From: Anita Gardner <Anita.Gardner@arun.gov.uk>
Sent: 23 July 2020 15:26
To: Planning.Responses <Planning.Responses@arun.gov.uk>
Subject: FW: Application CM/20/20/PL amend inaccurate Proposal description please

I am writing to you to ask you to amend the Proposal description for my Planning Application
CM/20/20/PL

1091/DPA01

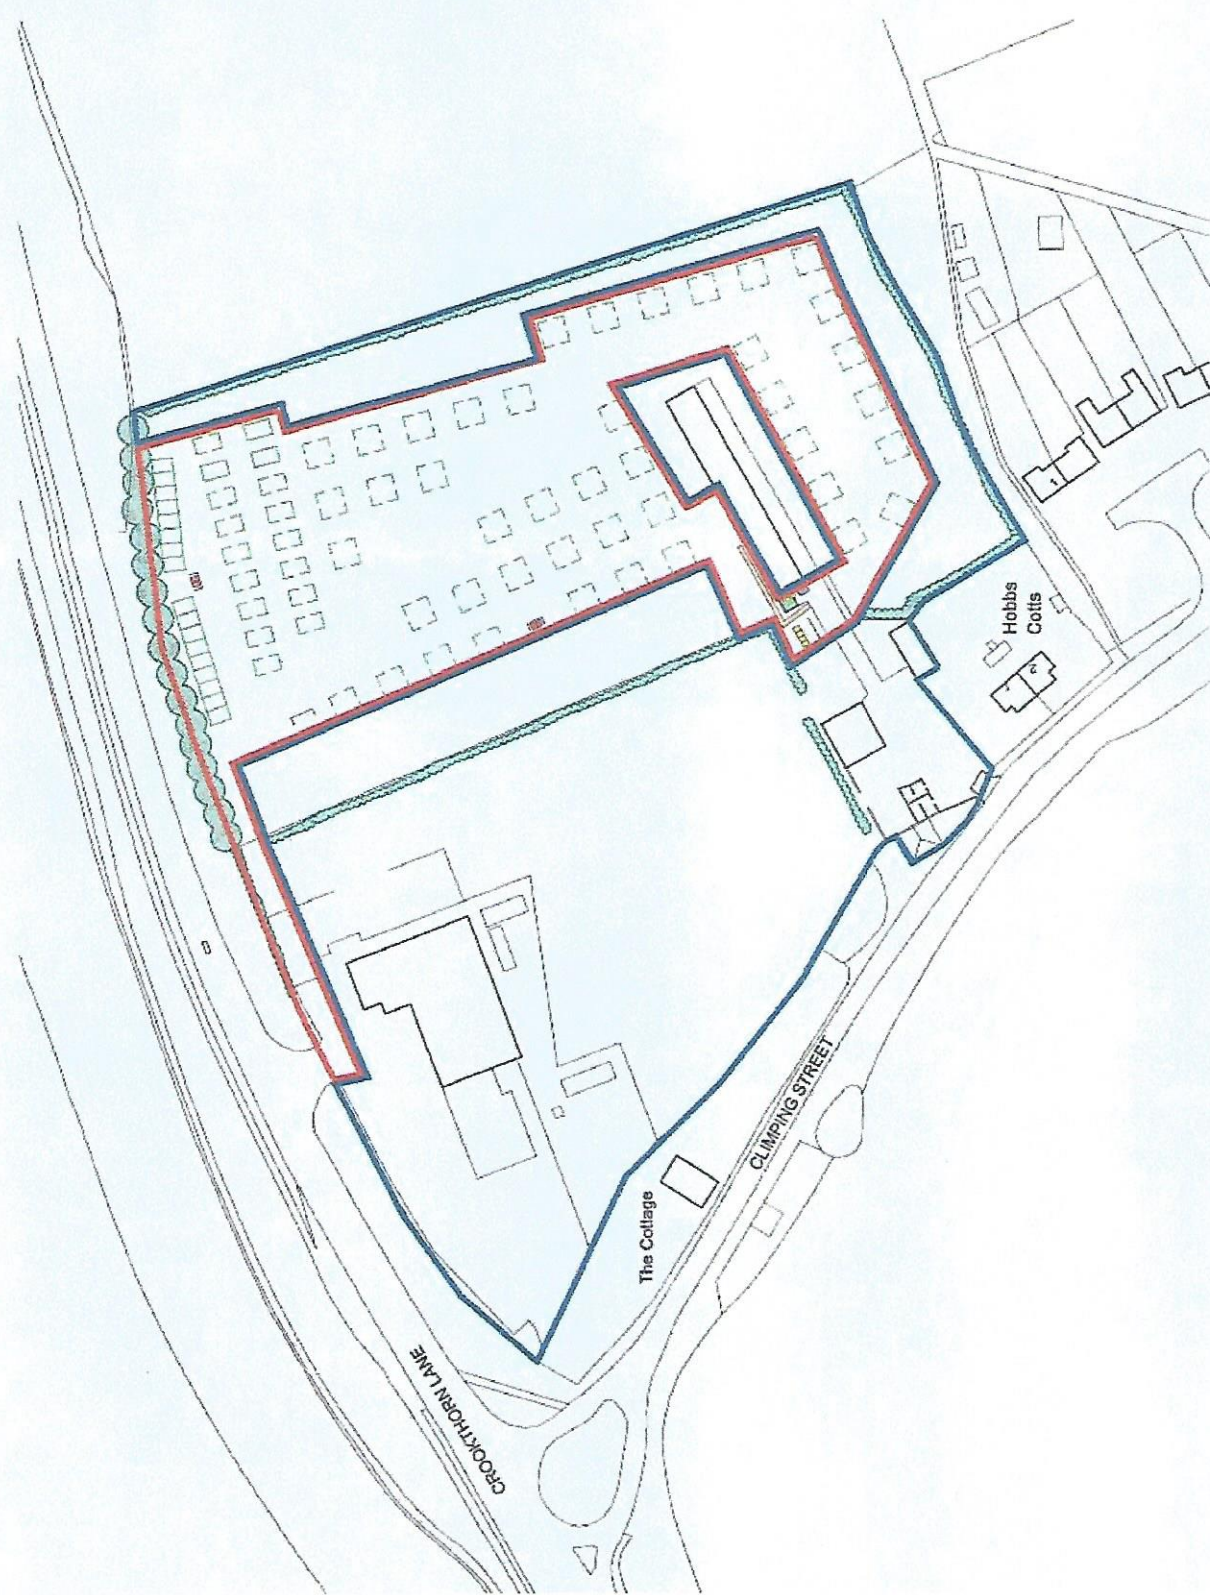
I note in your original letter you stated 'I will install fresh running water taps at each pitch to further reduce any risk of contact between Campers.'

I can't see these indicated on the substitute block plan.

To clarify can you advise if this is still your intention and if so indicate their position on the submitted block plan? Can you also advise what would happen to these taps at the end of each season when the site is not in use for camping?

The water pipe network will be temporary and we will run the blue plastic pipes on top of the ground to each pitch, a short wooden post will be driven into the ground to support the Taps. as this is the summer time, the ground will be hard enough to support this without any need for concrete. The whole infrastructure can be dismantled and removed at the end of the season and stored away for the next one. We have excellent water pressure here and have already tested that this will work. I have a protocol in place to run each of these taps every week, so even if the pitch is not occupied the water is not stagnant in the pipes.
